Arun District Council
Arun Civic Centre
Maltravers Road
Littlehampton
West Sussex BN17 5LF
Planning & Building Control General Enquiries
Tel: (01903) 737756 Fax: (01903) 730442
Dx: 57406 Littlehampton
Minicom: 01903 732765
e-mail: planning@arun.gov.uk
website: www.arun.gov.uk/planning

Application No: WA/63/21/PL
Site Address: Land East of Tye Lane Walberton BN18 0LU
Description of works: Proposed alternative vehicular accesses off Tye Lane and emergency access off Avisford Park Road, along with minor highway works following WA/95/18/RES (resubmission following WA/93/20/PL). This site is CIL Zone 2 (Zero Rated) as other development.

Thank you for your internet representation made on 5th August 2021 which has been recorded as an objection with the comments as follows:

VIEWPORT 4 - PROPOSED EMERGENCY ACCESS AT AWISFOD PARK ROAD

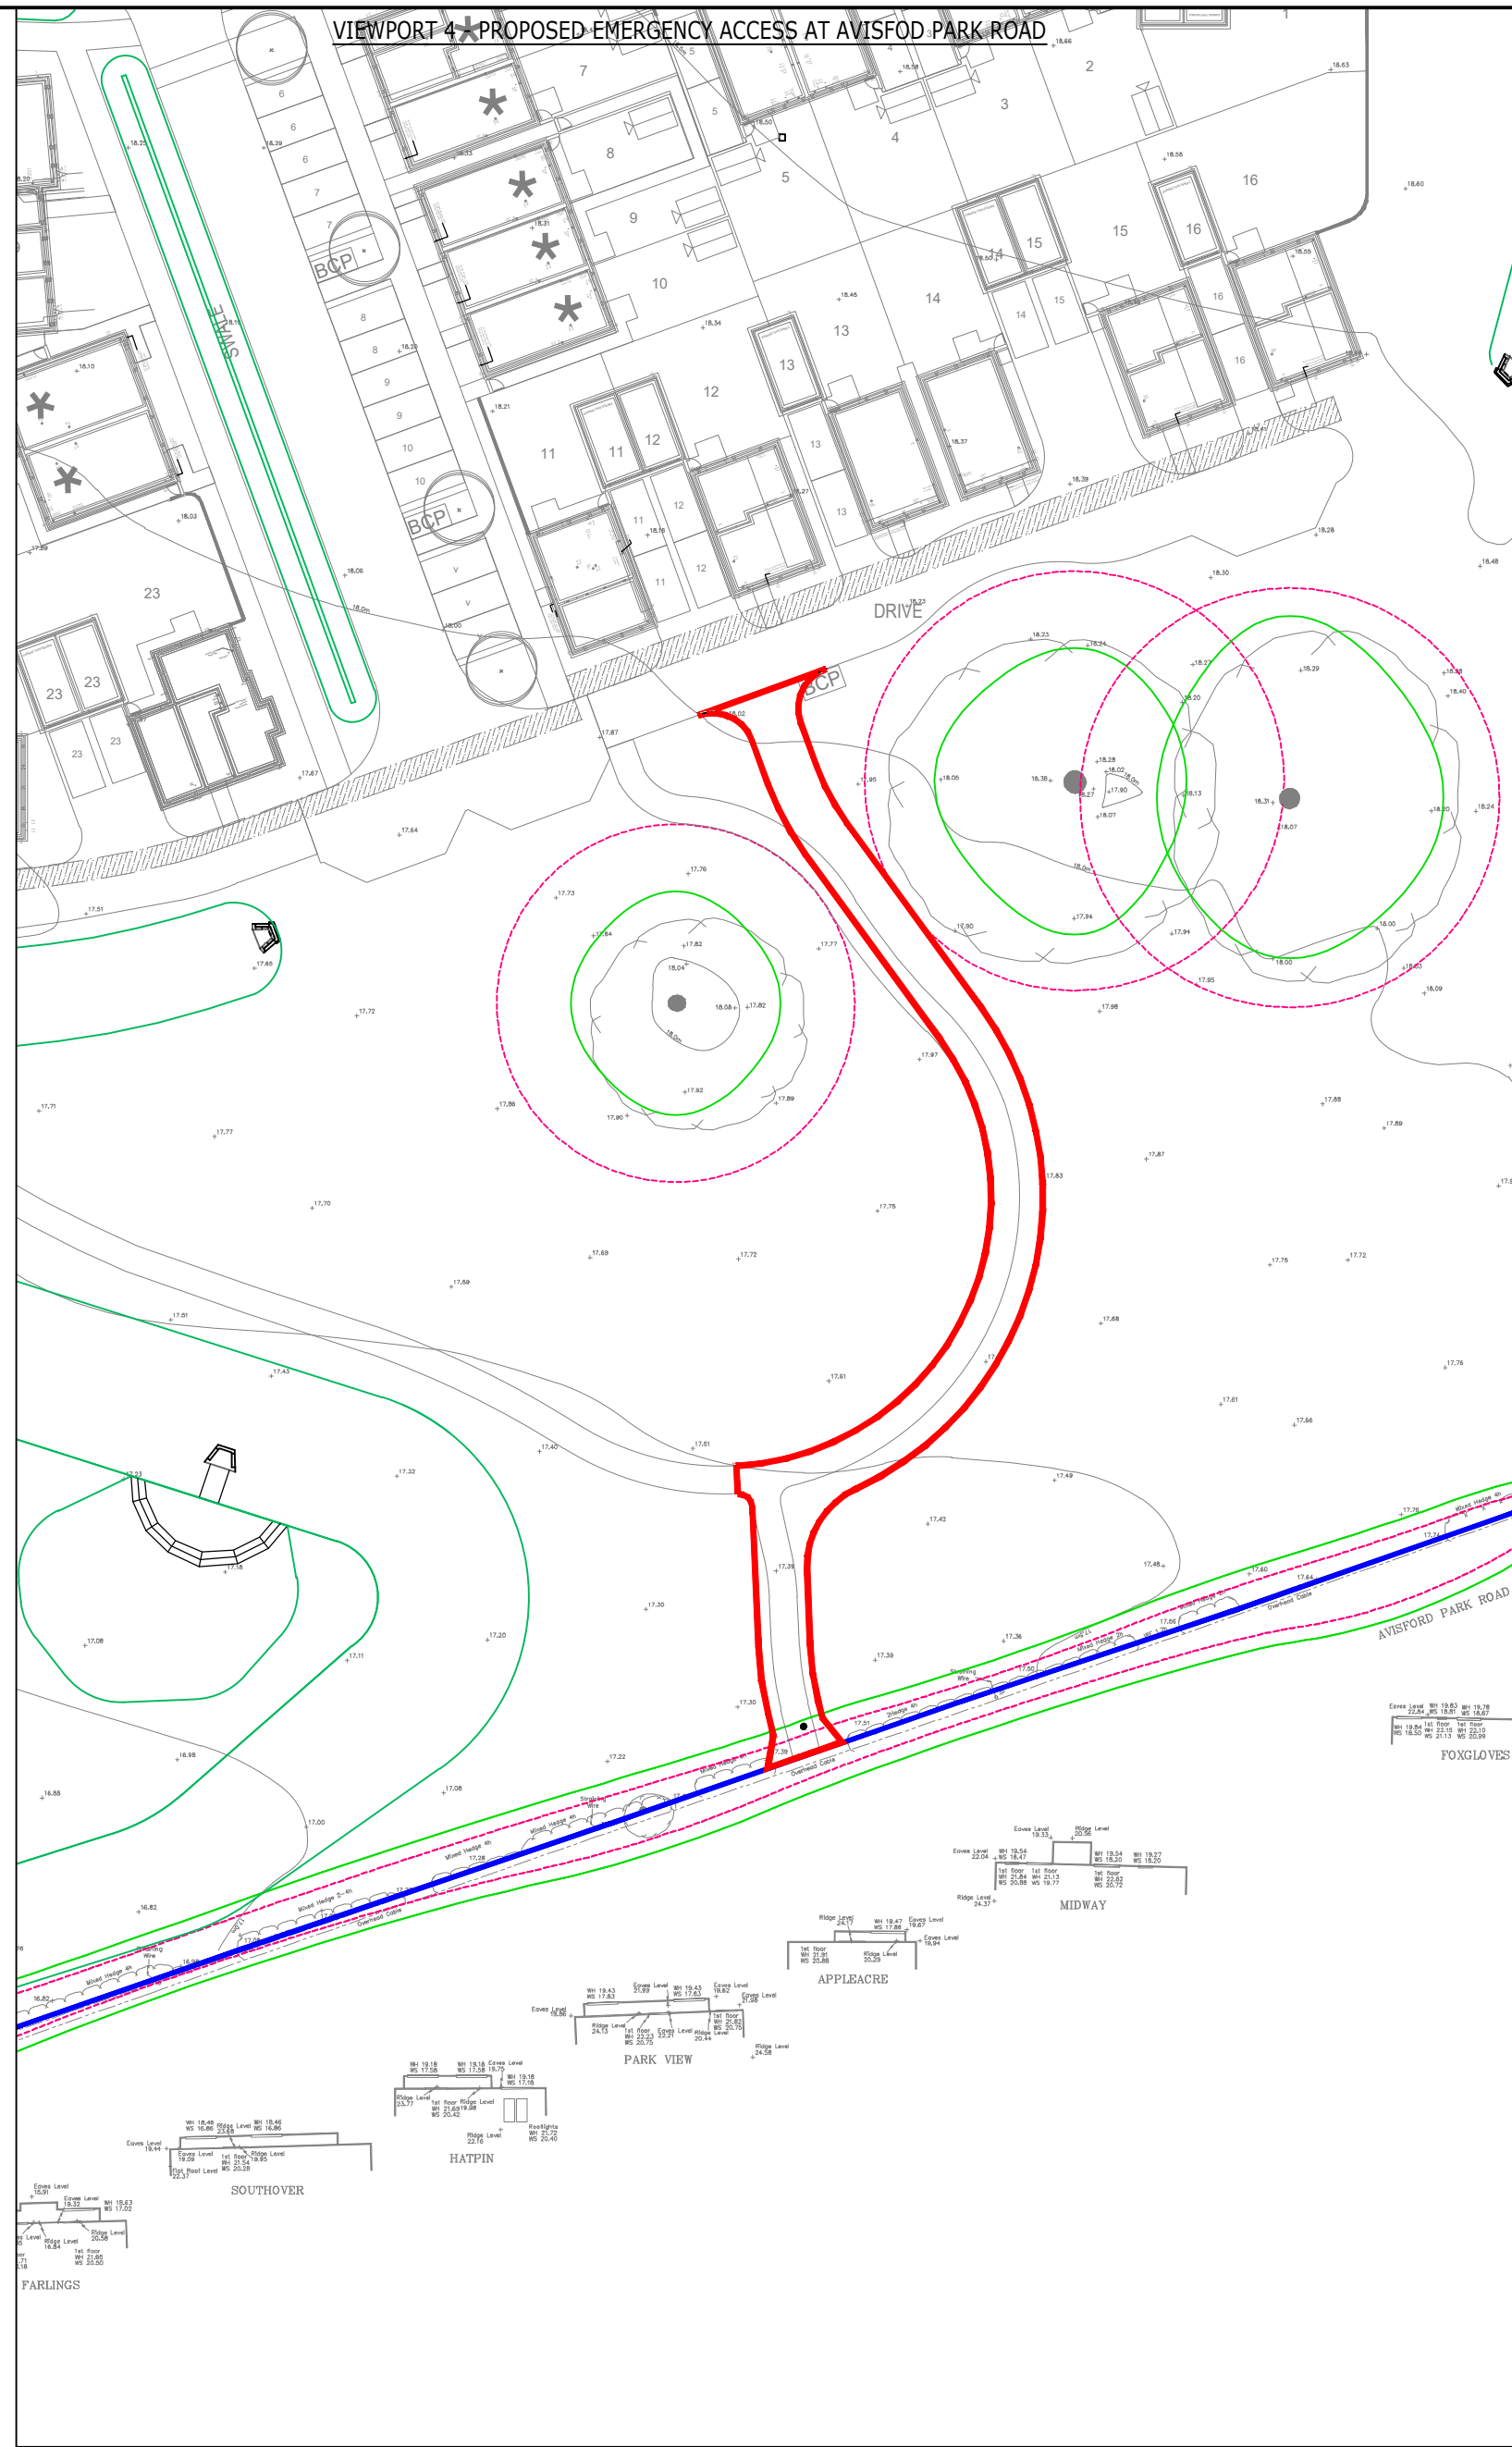
Avisford Park Road is a dead end, the flawed plan showing emergency vehicles entering/exiting east and west is another example of incompetence. Unless they expect a slim line fire tender to go down the footpath. The access point in Avisford Park Road should remain as originally planned, pedestrians only, by the playing field. The width, surface and underlying bedrock of the road is already straining under too many vehicles being driven too fast and the costs have to be born by the residents. The buffer zone of trees and water would
